**WEST YORKSHIRE
POLICE**

Architectural Liaison Officer

To: Nick Hirst Investment & Regeneration Service Kirklees Council Civic Centre 1, Huddersfield, HD1 2EY	Ref: 2017/93396 Date: 7 th November 2017
------------------------------------------------------------------------------------------------------------------	--------------------------------------------------------

**Vale Works, Morley Lane, Milnsbridge
Demolition of existing industrial buildings and erection of 18 apartments**

DRAWING TITLE: PROPOSED DRAWINGS
GA GROUND FLOOR LEVEL PLAN

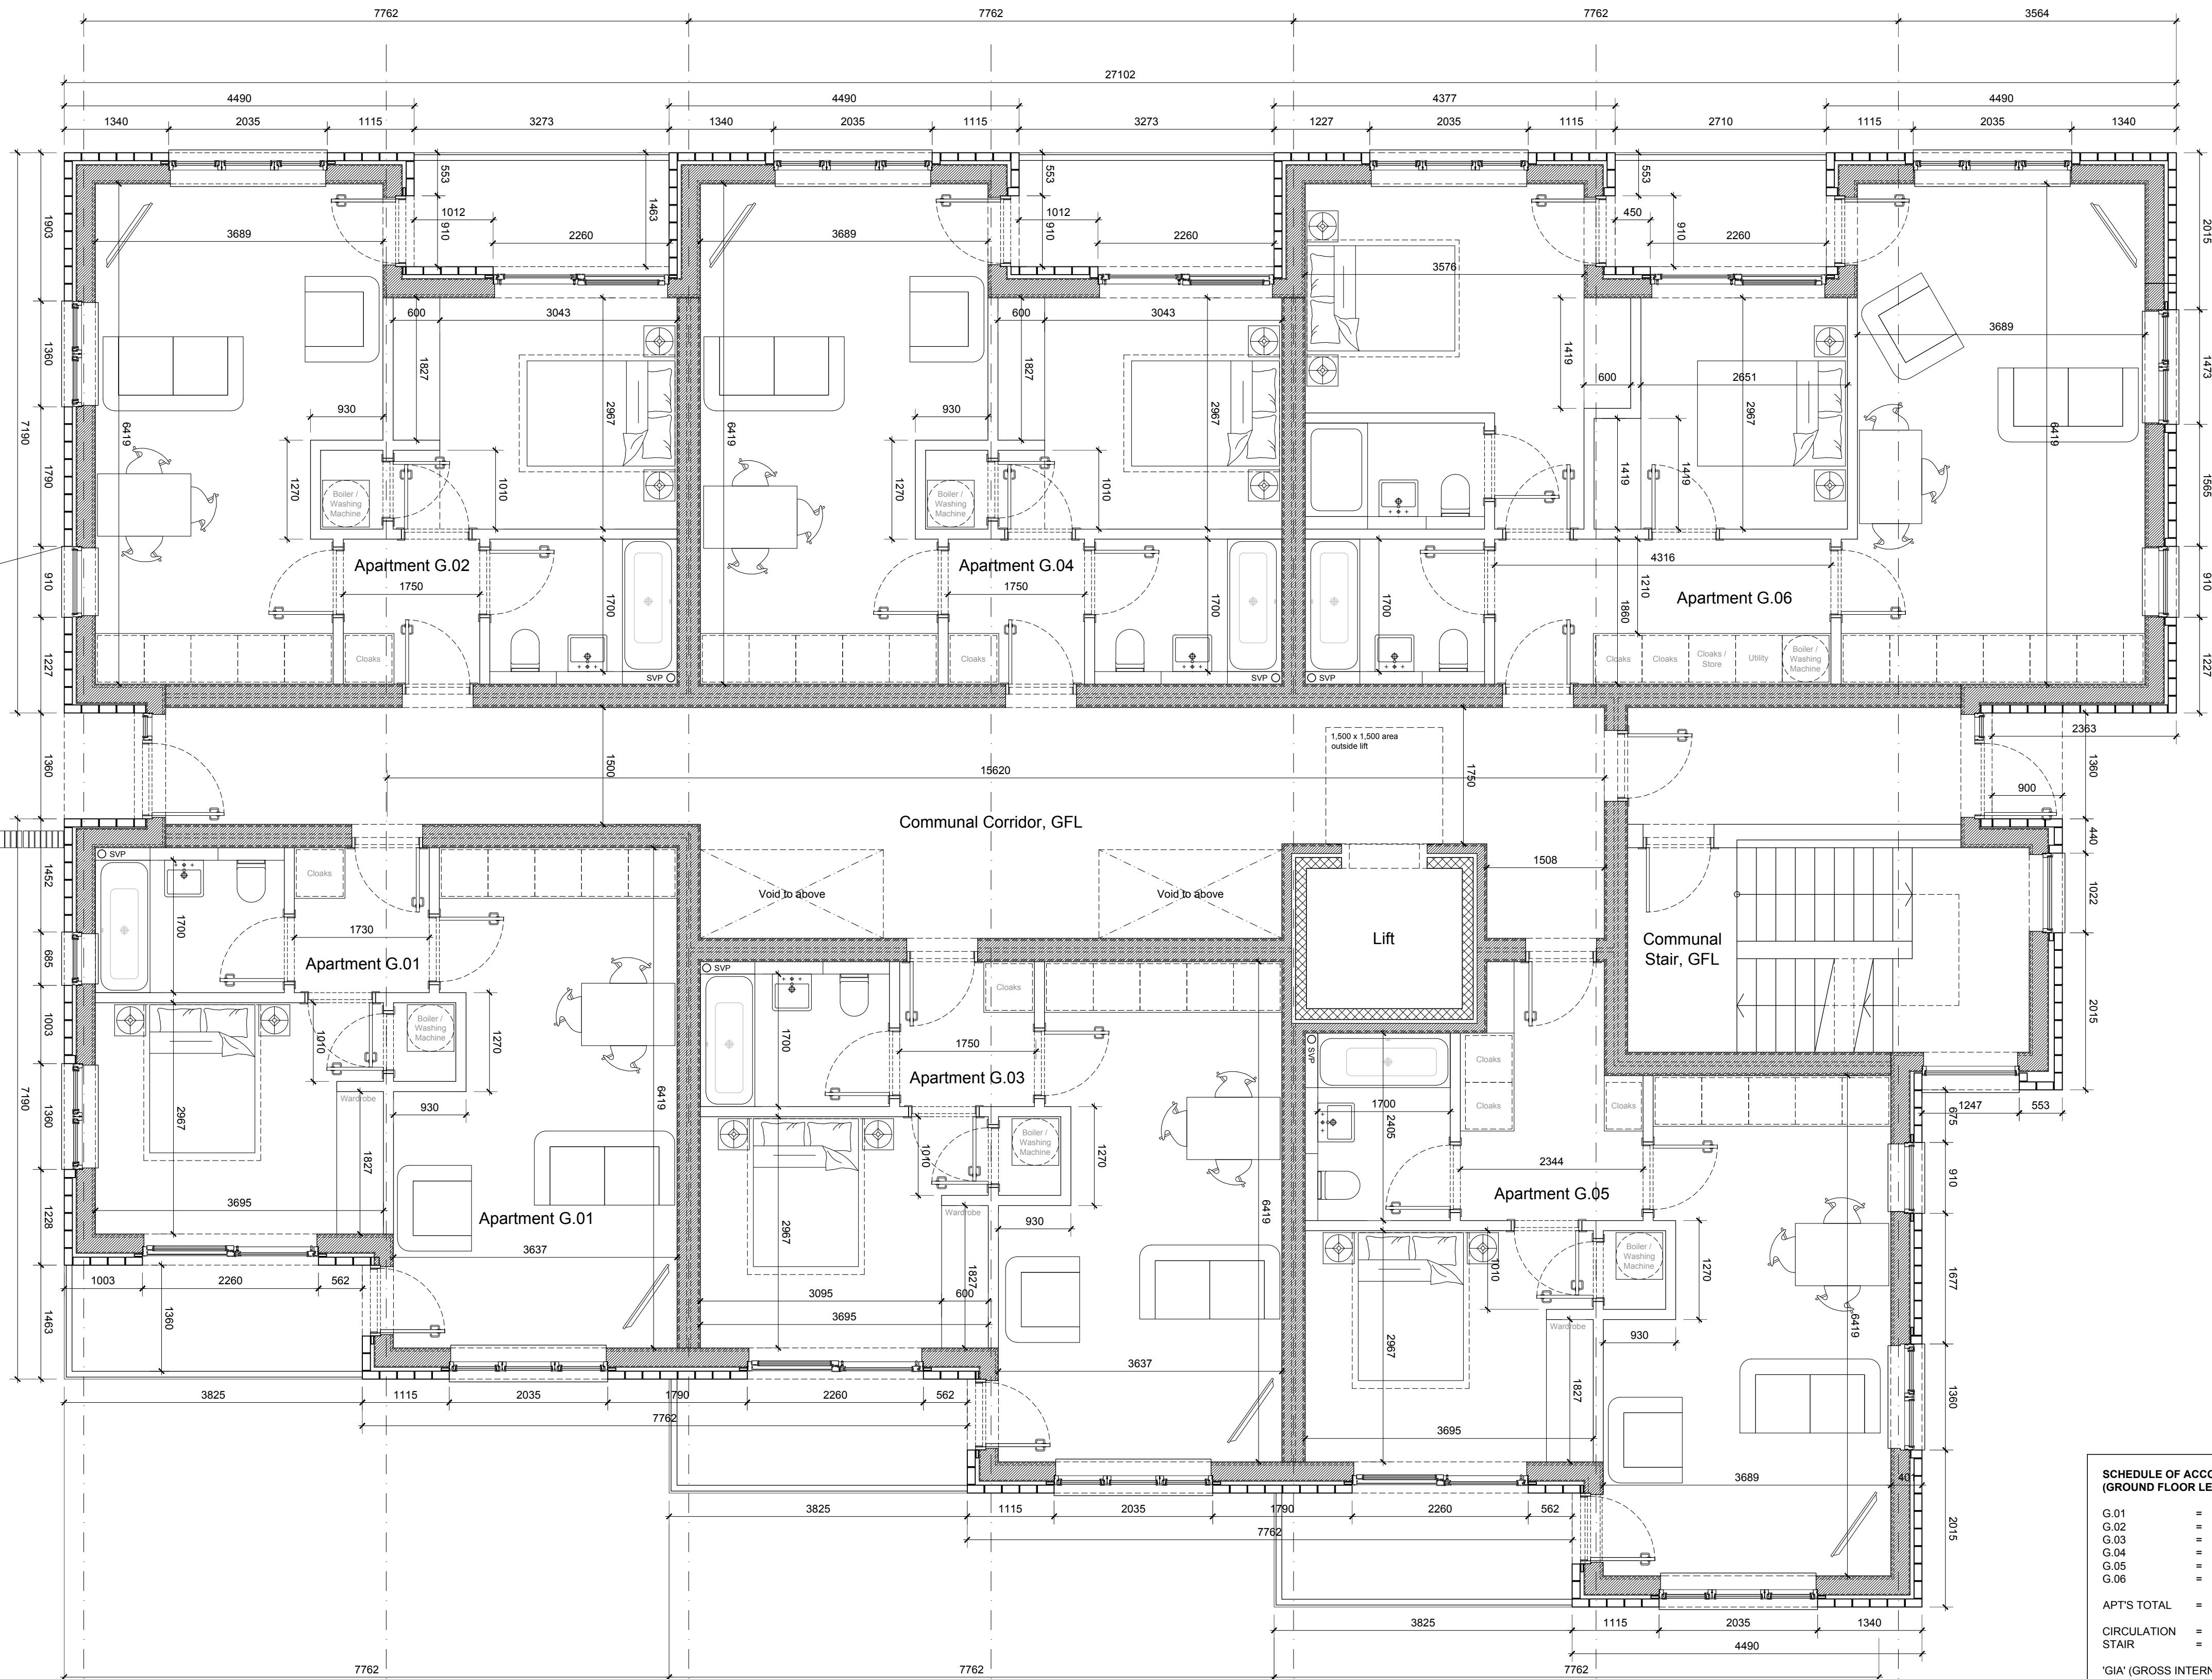
Control of access into the apartment block

Multiple occupancy buildings need to have a visitor door entry / access control system.

Any persons gaining unauthorised access into the building could have a great degree of anonymity and the opportunity to have free roam within the corridors, possibly looking to burgle individual flats, or commit other crime / anti-social behaviour.

An access control system providing the following attributes is urged:

- Access to the building via use of a restricted electronic key fob, card or key
- Vandal resistant external door entry system panel with an integral camera
- Remote release of the external entrance door from the individual apartment
- Audio and visual communication between the occupant in the apartment and the visitor at the external door
- Capture (record) images in colour of people using the door entry panel
- Battery back-up facility in case of a power failure in the system

**DRAWING TITLE:** PROPOSED DRAWINGS  
SITE LAYOUT PLAN

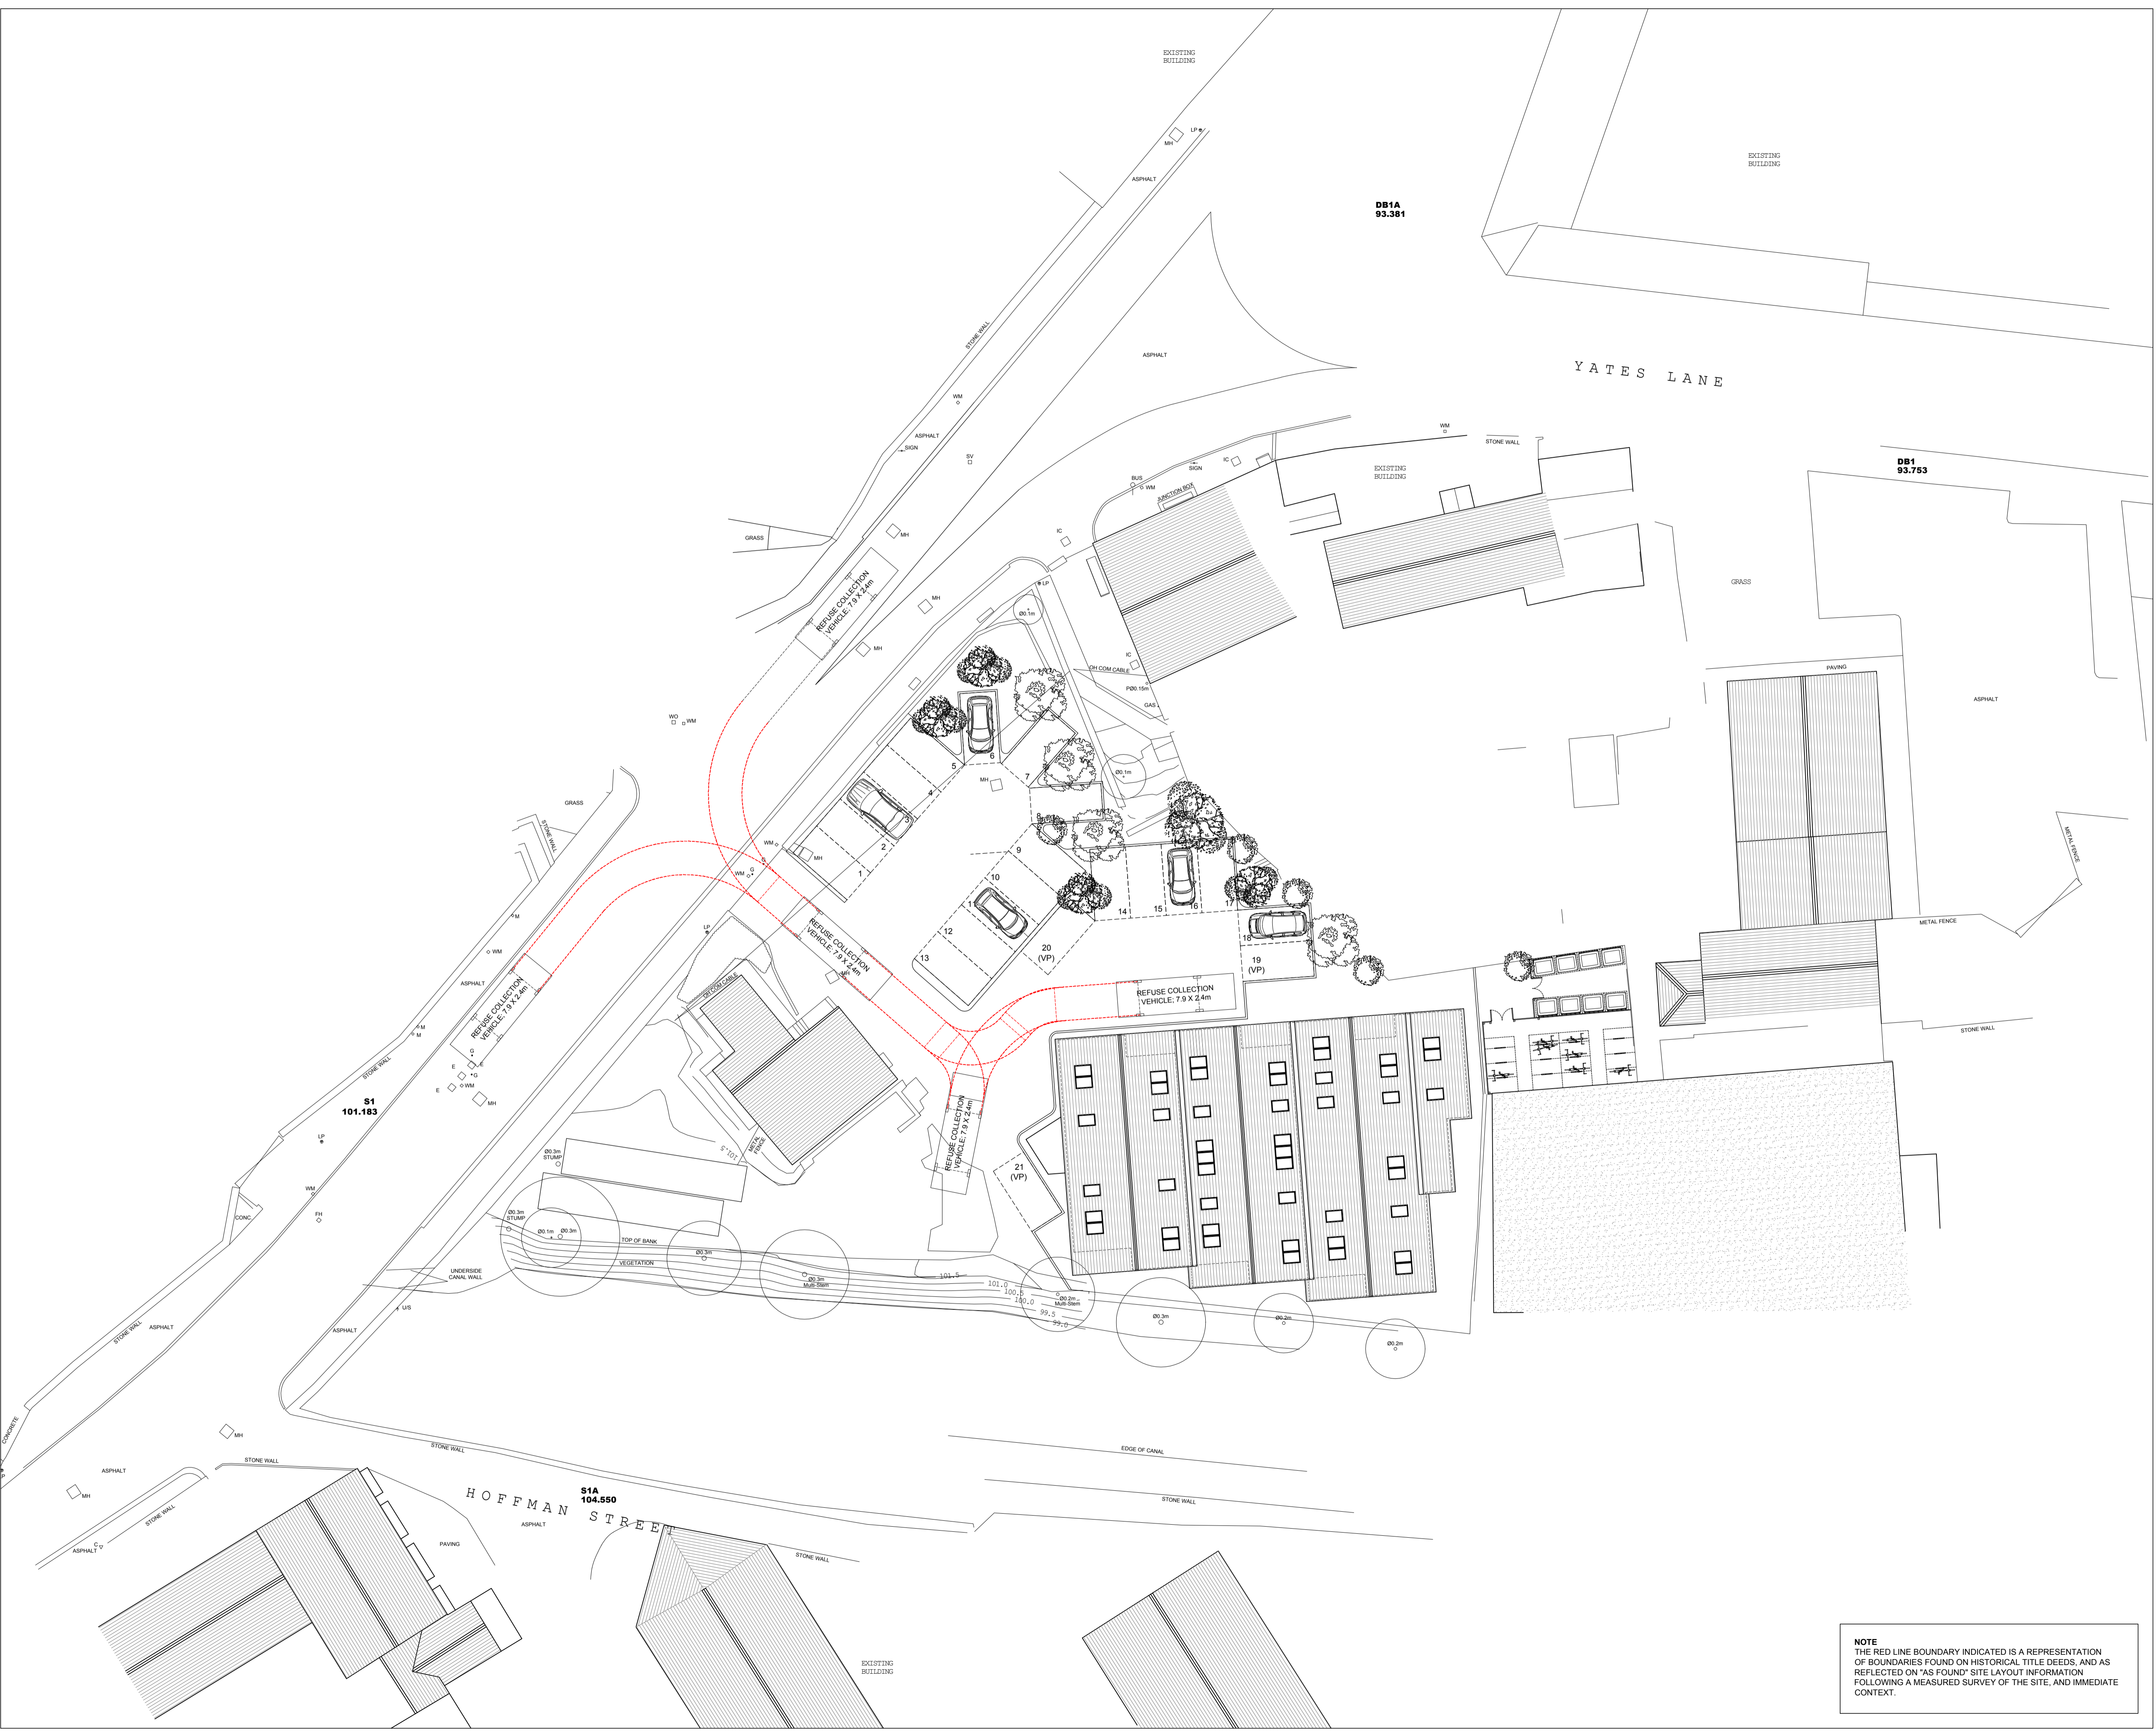
Parking area lighting

The car parking areas need to be provided with a suitable lighting scheme to maintain adequate surveillance of parked cars and to assist with the safety of residents using the car park, and other external areas during the hours of darkness.

Cycle storage

How is this area intended to be made secure? Unless it is adequately secured, it will not be used for its intended purpose.
